MEMORANDUM

TO: Jean Fraser
FROM: Dan Goyette, PE
DATE: July 31, 2008
RE: 355 Warren Avenue

Woodard & Curran has reviewed the Application for Site Plan Review for 355 Warren Avenue in Portland. Stormwater drainage improvements are proposed in the "tow yard" including two new catch basins, a new drain manhole and 158 feet of storm drain. The project includes associated grading.

# 355 WARREN AVENUE PORTLAND, MAINE

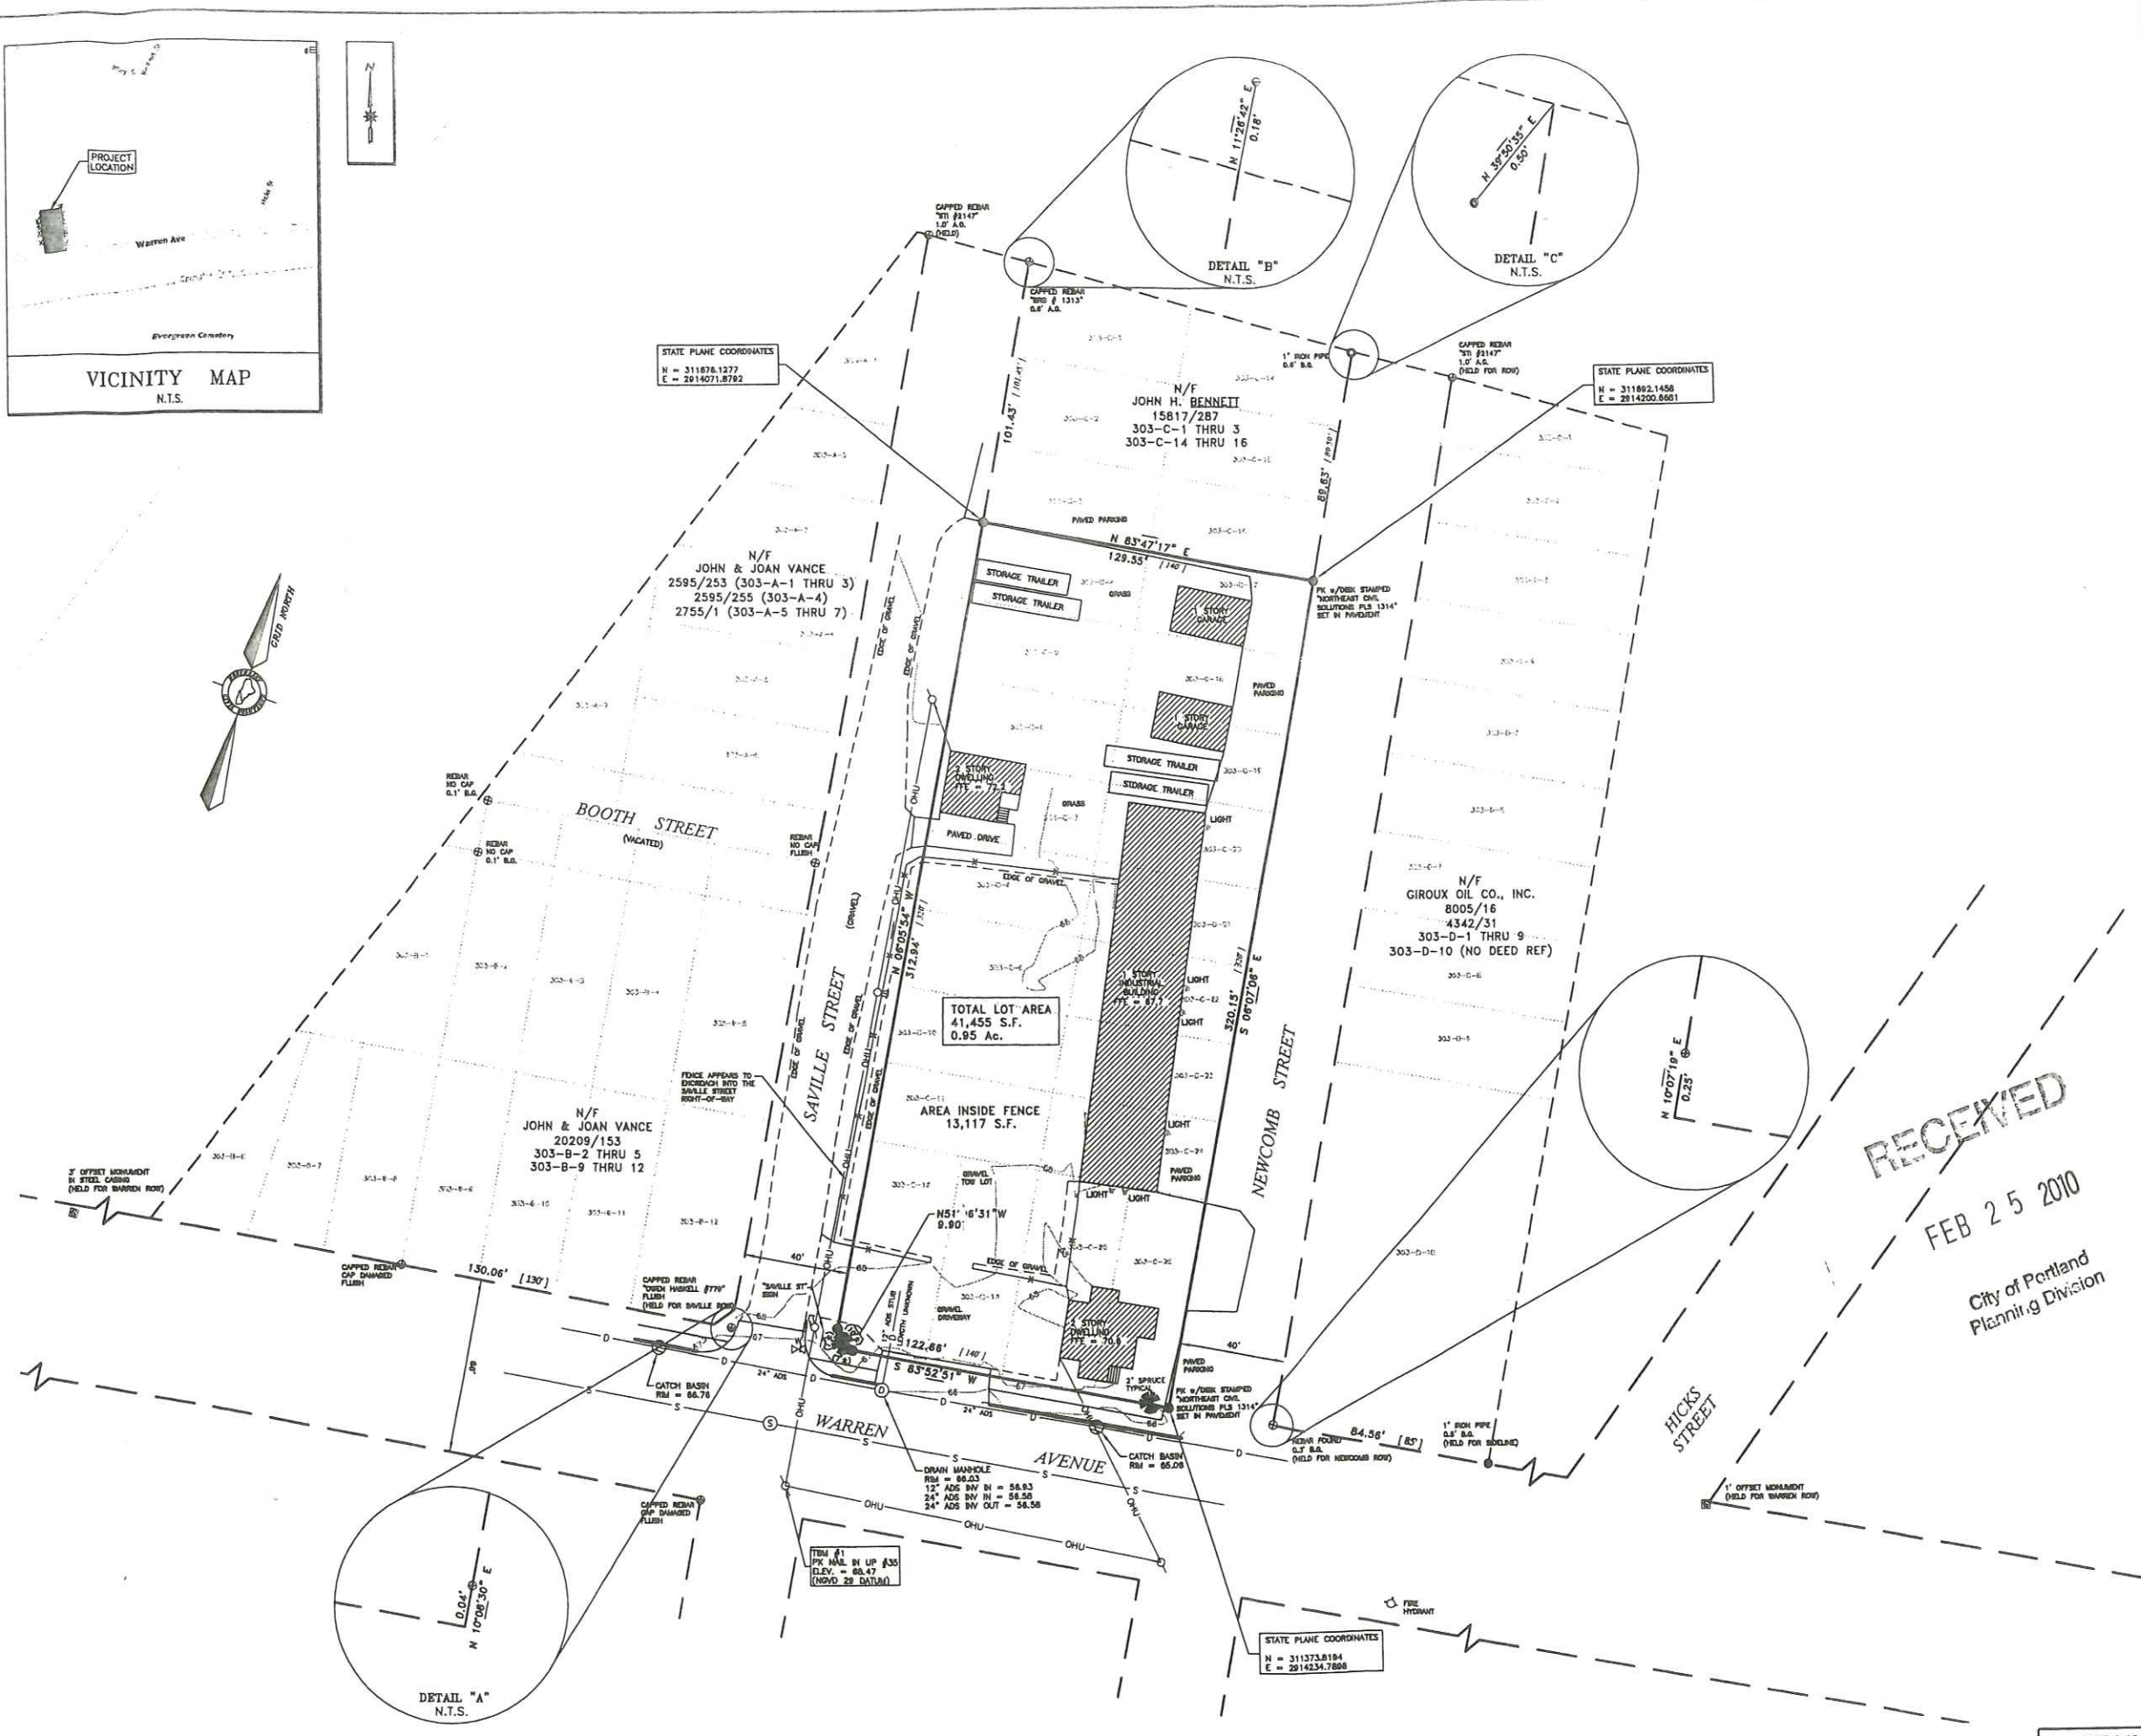
- The narrative lists 355 Warren Avenue but the plan cover page lists 38 Warren Avenue as the location for the project.

Boundary Name and Location  
**BOUNDARY SURVEY/EXISTING CONDITIONS**  
 355 WARREN AVENUE, PORTLAND, MAINE

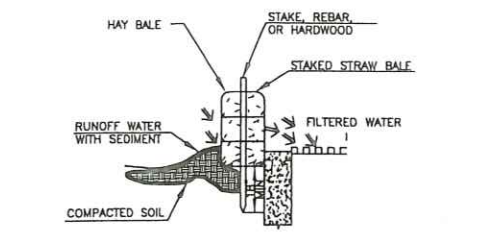
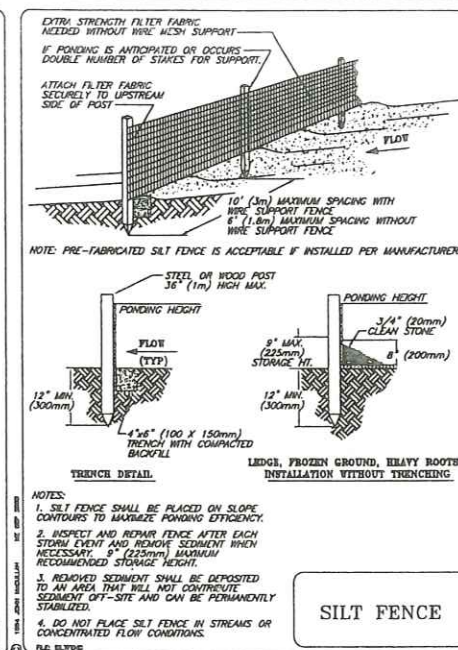
- The applicant should confirm that the survey for the project coincides with approved City standards. The applicant states that this requirement has been waived but we are not aware of any such agreement. If there is not an agreement, the survey needs to be tied to the vertical datum of NGVD 1929. Also, the project needs to be tied to the Maine State Plane Coordinate System (2-zone projection), West Zone using the NAD 1983 (HARN) Datum and the U.S. Survey Foot as the unit of measure. This should be indicated on the survey.

NOTE: MANHOLE, FRAME AND GRATE SHALL BE DESIGNED TO WITHSTAND H-20 LOADING.  
**PRECAST CONCRETE DRAIN MANHOLE**  
 N.T.S.

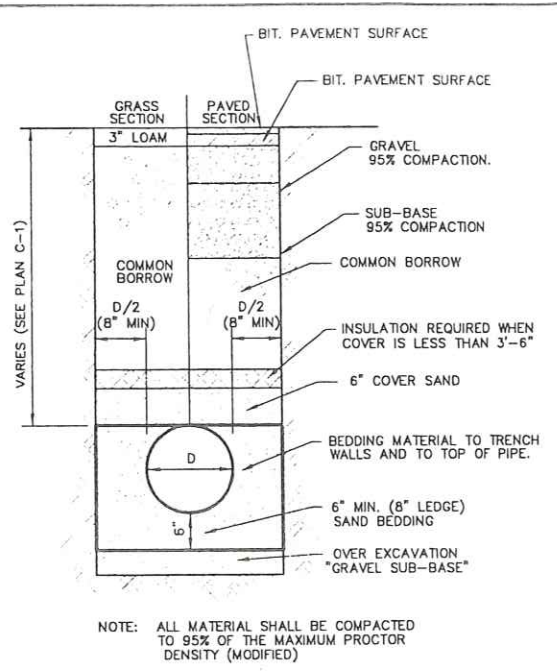
- Erosion Control Measures have not provided.
- Provide 12" of crushed stone over storm drain pipe.
- The manhole detail shows only RCP while the plans show ADS N12 pipe. ADS N12 pipe is not allowed within the City Right-of-Way.

NOTE: CATCH BASIN, FRAME AND GRATE SHALL BE DESIGNED TO WITHSTAND H-20 LOADING.  
**PRECAST CONCRETE CATCH BASIN DETAIL**  
 N.T.S.

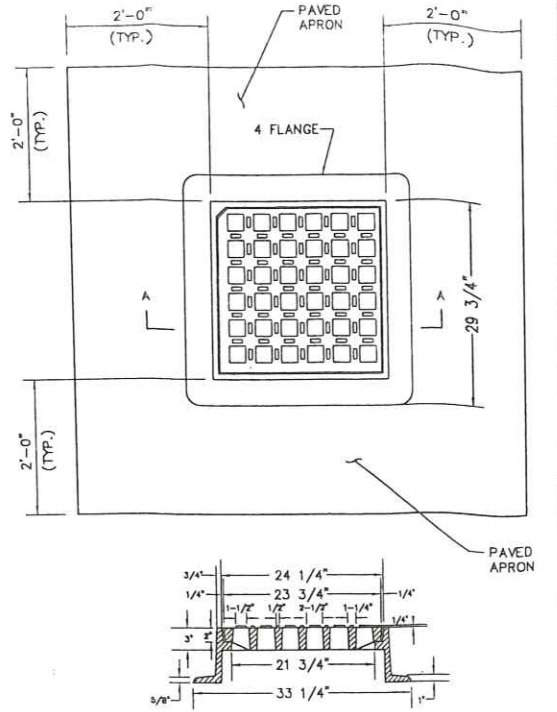
- The catch basin detail should call out a Casco Traps and a detail for the Casco Traps should be provided.
- A Stormwater Management Plan has not been provided. Based on the available parking spaces, stormwater treatment will be required.
